**Town and Country Planning Act 1990
Application for Permission to Develop Land**

Response from Pollution & Noise Control

PNC Reference No:	WK/201603005
Name of Planning Officer dealing with the matter:	Farzana Tabasum
Application Number:	2016/62/90367/W
Proposed Development:	Erection of agricultural workers dwelling and change of use of agricultural land to domestic.
Location:	Harrison Lane, Meltham, Holmfirth, Kirklees
Date Required By Planning:	2nd March 2016

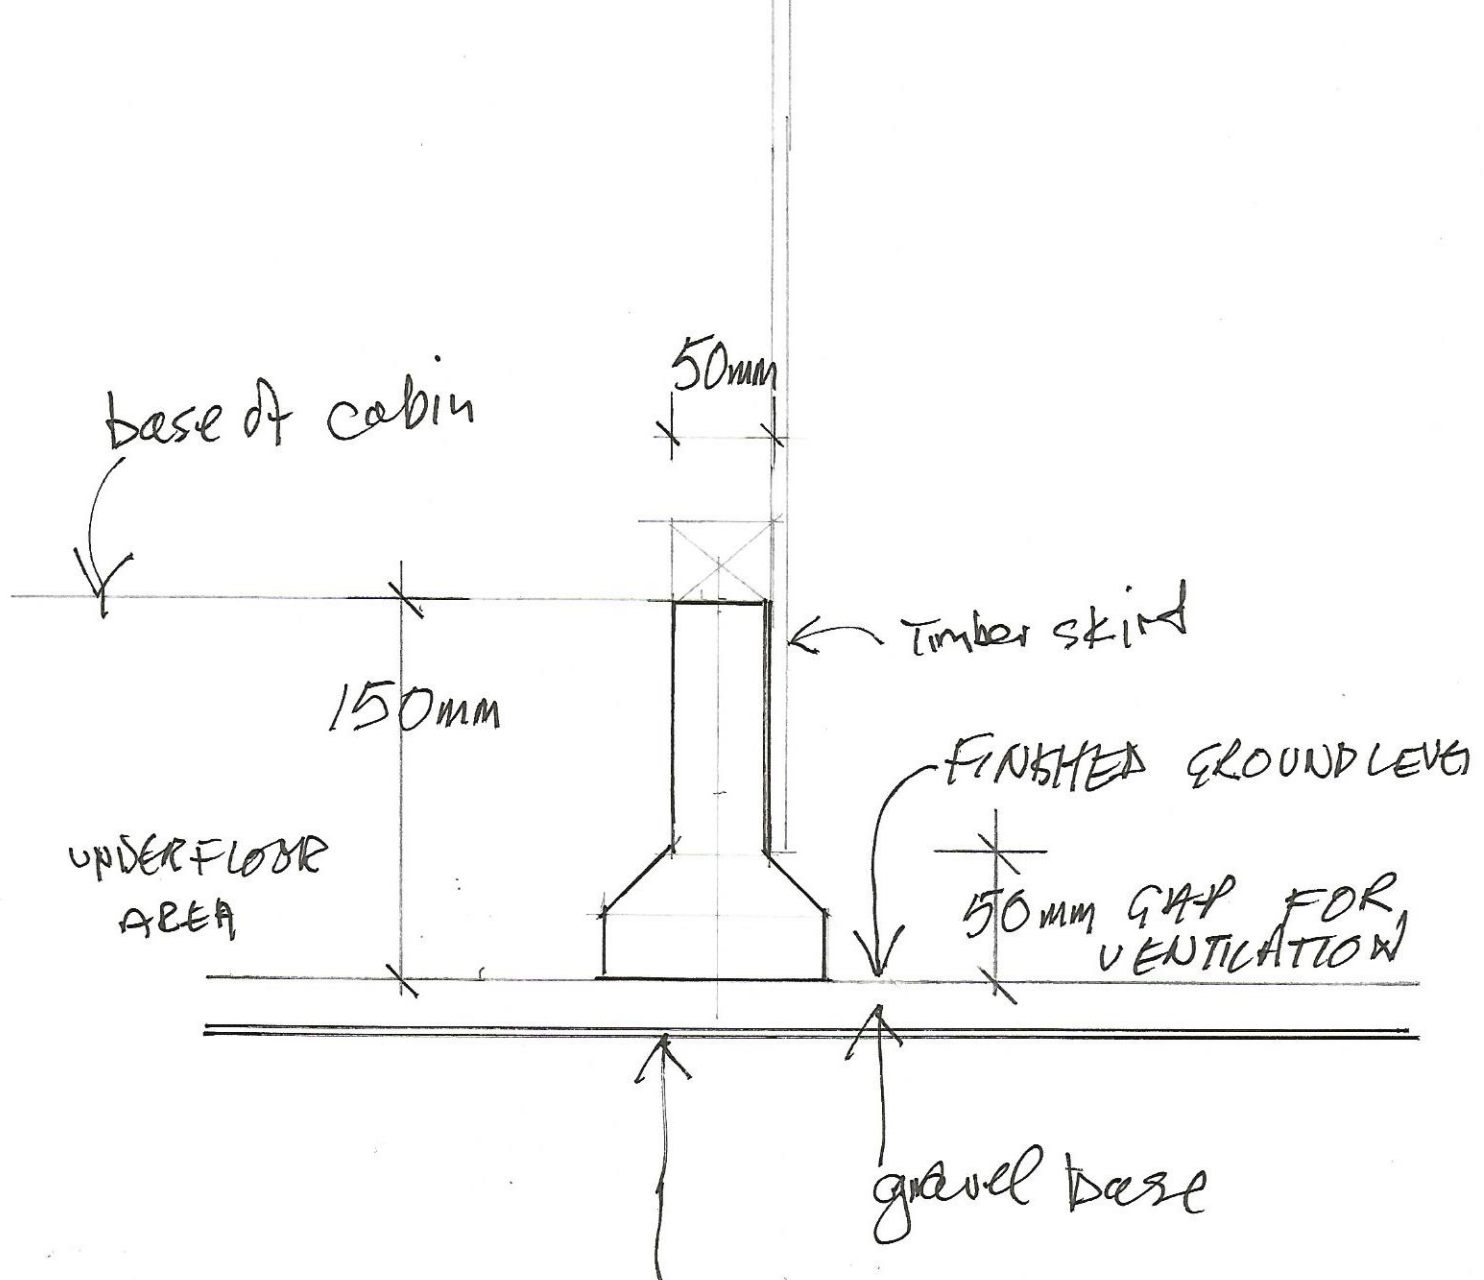
I have looked at the proposed package treatment plant (Balmoral Hydroclear 6) and it looks to be a suitable unit in terms of capacity for this application. I therefore recommend that the following condition is applied to any consent granted:

The package treatment plant to be installed shall be the **Balmoral Hydroclear 6**, and this shall be installed as per the submitted plan (planning reference 574112). I f this unit cannot be
